St. John Street Garage Site Plan Application Responses to Public Comments

August 2018

PHASE 1 LOGISTICS PLAN SEPTEMBER 2018 - SUMMER 2019

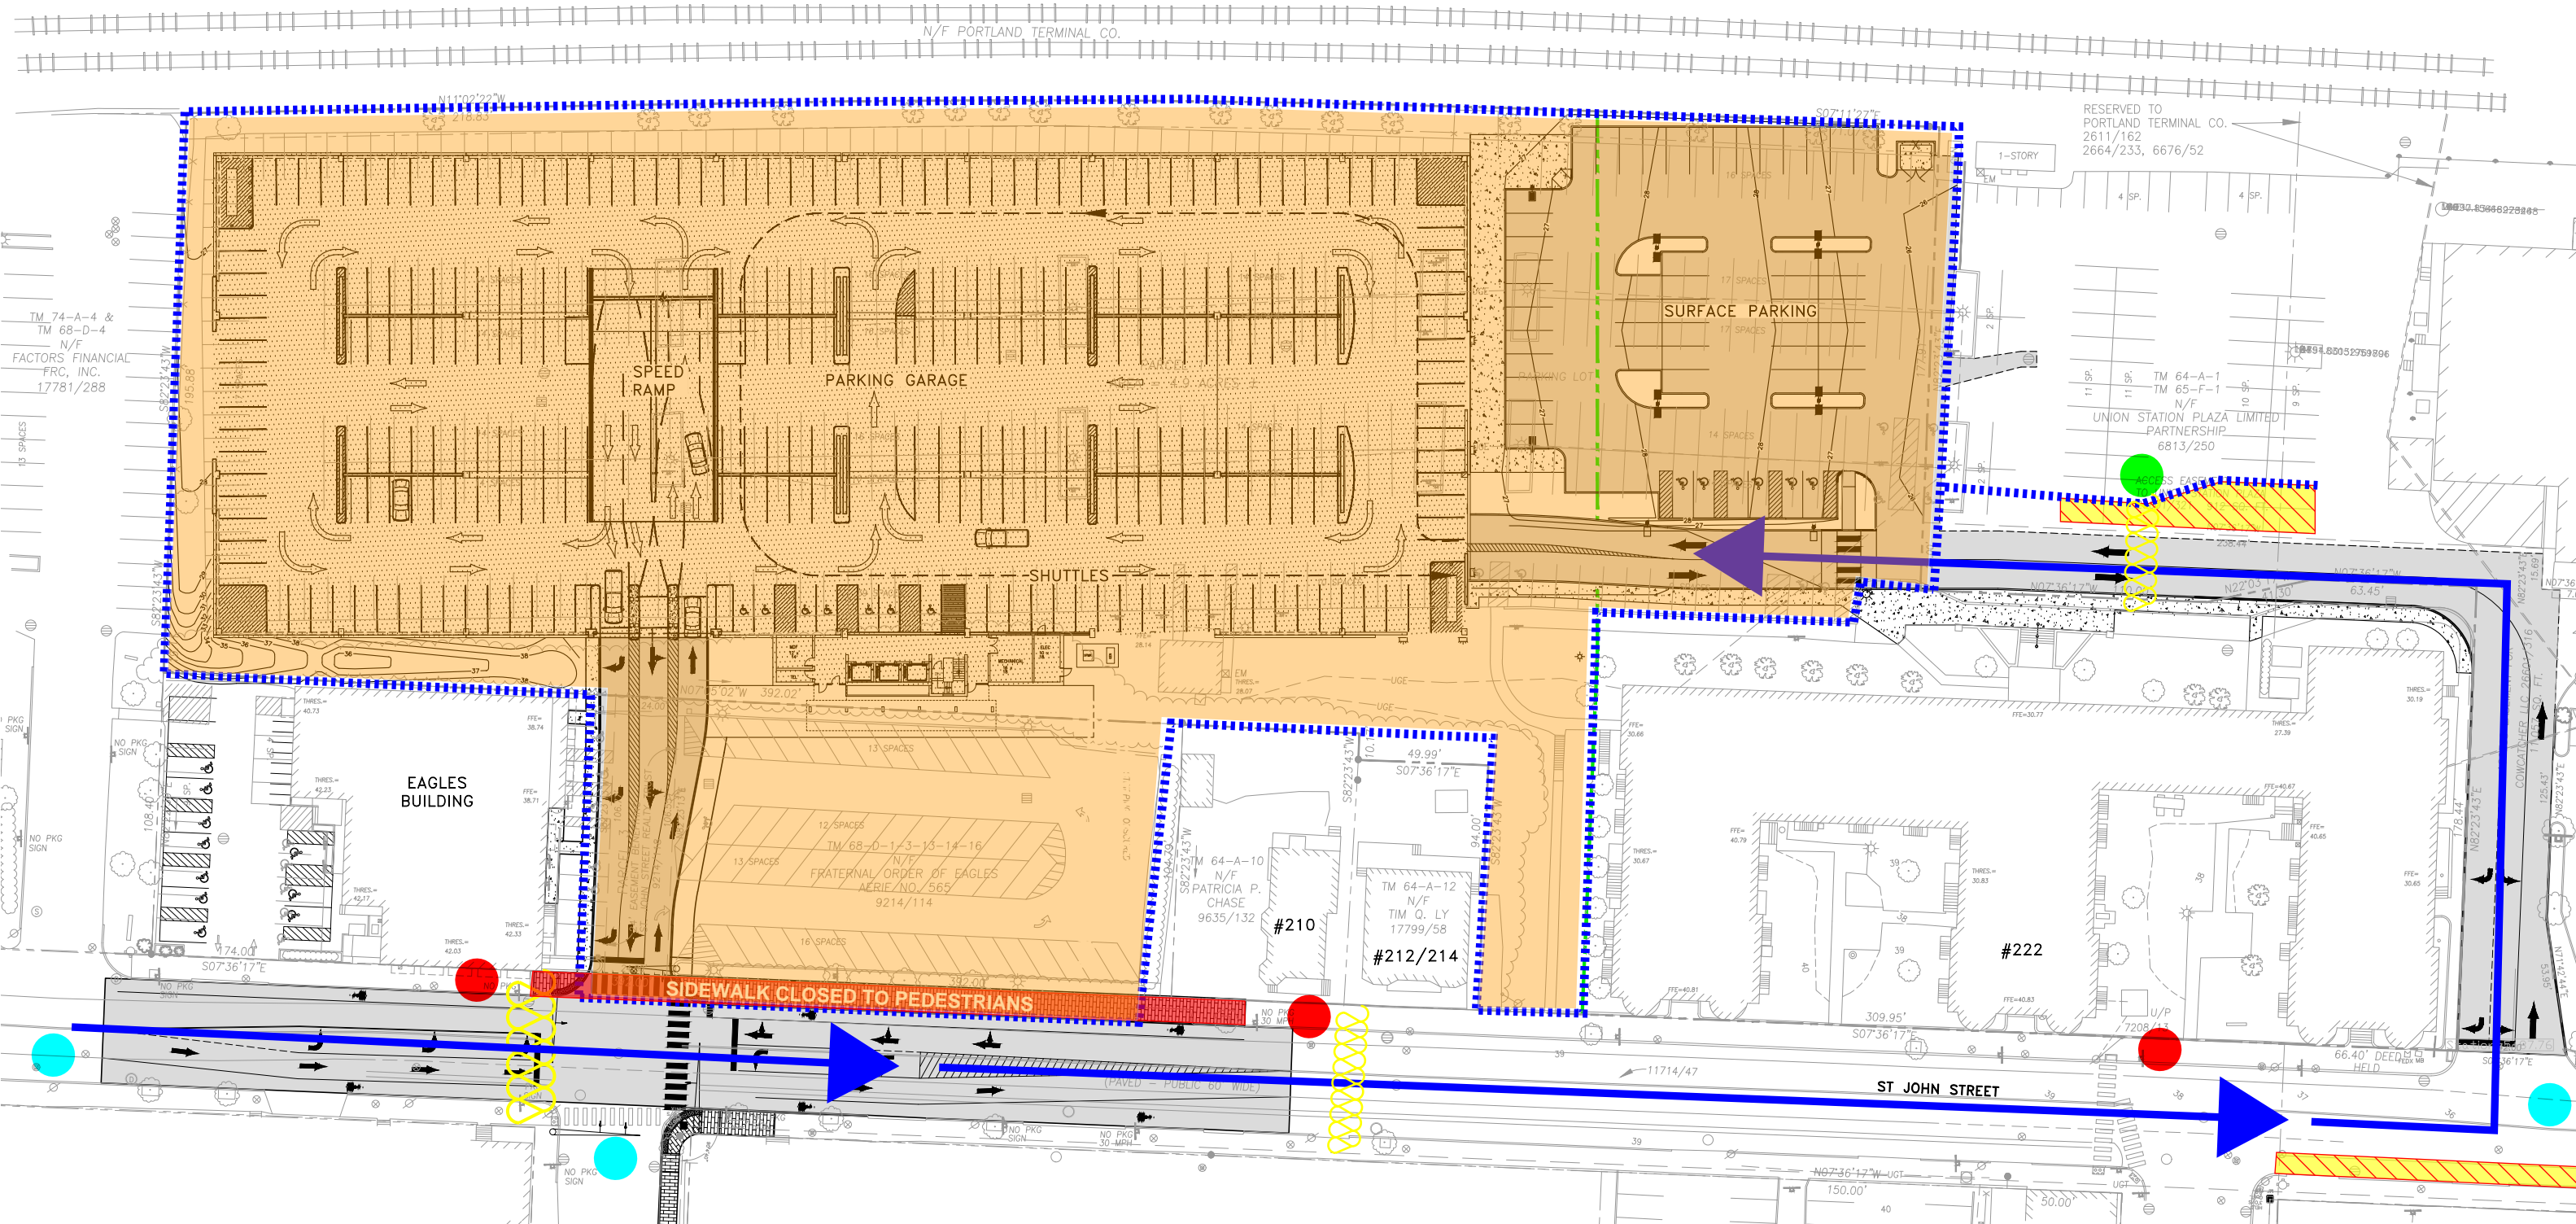
Because MMC ran out of time at the Planning Board Workshop on July 10th to present info on the construction phase of their project, I have some questions and concerns about how all that construction traffic will impact not only those of us who live within close proximity of the temporary entrance to the site, but also the flow of traffic in general on the street. Most of my concerns are with noise, construction vehicles gearing up and down while turning into and leaving the construction site, traffic back ups, etc. I realize that we can't eliminate the traffic and noise, but what has MMC planned to help mitigate these concerns as much as possible during the construction phase?

Response: Construction of the garage will require careful planning and management of the daily occurrences within the site limits. The logistical plan that is currently outlined is intended to keep all construction staging, laydown and temporary storage within the project limits and secured by temporary fencing. With designated areas delegated to subcontractors the site will remain accessible by incoming trucks without causing a queuing affect outside of the fence. A

secondary storage yard is anticipated near the project site to store precast material not accommodated on site. The usage of this area will help to better control and manage the truck traffic to and from the site during the day, as nighttime truck use is prohibited by State of Maine. Precast trailers will only transport loads between the staging yard and the job site outside of peak traffic hours as defined by Gorrill Palmer as 7:30am – 8:30am and 4:00pm – 5:00pm.
